Woollahra Municipal Council

RE: Urban Design Review of 2-6 Conway Avenue, Rose Bay, – SSD- 101842729

Studio GL were asked to review the SSD plans for 2-6 Conway Avenue, Rose Bay. The review identifies the key urban design related matters, identifies concerns and suggests amendments that could reduce these impacts. The review relies on the information provided by the proponent.

Figure 4: Annotated Section A-A
Source: Section MHNDUNION, Annotations Council Staff

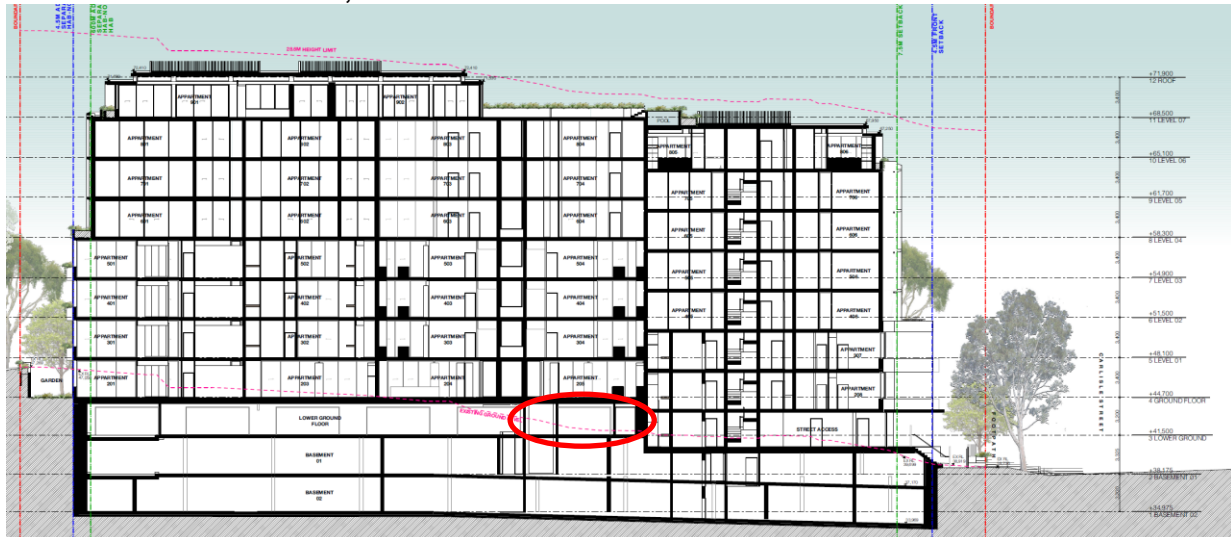
The principles and design strategies in the Design Report appear to consider the site as flat rather than one that has a 3.5m cross fall. It should also be noted that the middle of the site, where the building on 2 Conway Avenue sits, has been excavated to provide a car park under the building. This means the existing ground line is lower than natural ground and therefore in the middle of the site the proposal exceeds the maximum height limit. Refer Figure 1 for the existing ground line in consideration with the proposed development.

As indicated in the section provided (refer Figure 1), the proposed built form along the western boundary does not appear to achieve the required stepped setback distances as the building height increases. A response to these areas of inconsistency is noted below:

The proposal states that the development is within the maximum permissible FSR for development on this site. However, I consider that the FSR is slightly over as storage, garbage and services are only excluded where they are within a basement and large areas of the Lower Ground Floor are more than 1m above the existing ground level and therefore should be included in the floor area calculations. The lobby area in the lower ground floor, connecting the fire staircase, should also be included in the calculation of the gross floor area of the development.

- Consider removing Level 7 (the eighth storey), as it exceeds the permissible height plane. According to the ADG, a 5–8 storey building typically reaches approximately 25 metres in height. This adjustment will help improve the overall building bulk and scale while also reducing potential overshadowing impacts.

- If Level 7 is retained, a Clause 4.6 variation is required to address the non-compliance with the maximum height control, with clear justification provided in relation to the existing ground line determination in the proposal and its impact on the overall building height.

- If habitable rooms and balconies that are unscreened and have clear glazing below 1.5m are desired facing the western boundary these should be set back a minimum of 6m for levels 0-4 storeys (up to 12m) and a minimum of 9m for levels 5-8 storeys (up to 25m). Given the height of the proposed building, it is recommended that if habitable rooms without screening are desired for the upper levels facing west they are redesigned with a clear and significant step-back from the western boundary to meet this requirement, reduce bulk and scale, and limit overshadowing and overlooking impacts on the adjoining property.
